KITTITAS COUNTY COMMUNITY DEVELOPMENT SERVICES

August 28, 2025

RE: Deatherage Short Plat, SP-25-00006 – Explanation of Well Requirements

DEATHERAGE SHORT PLAT

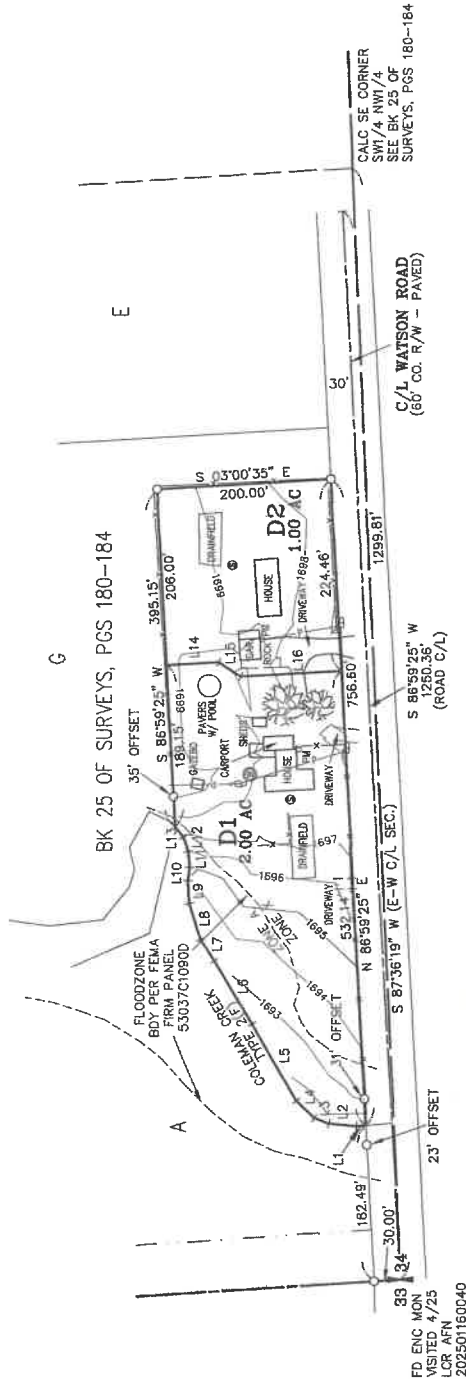
"A subdivision with nonpublic wells must provide a 100-foot water supply protection zone for each existing and proposed well. This protection zone must fit within the lot lines, or a copy of a restrictive covenant must be provided to each property located partially or entirely within the protection zone."
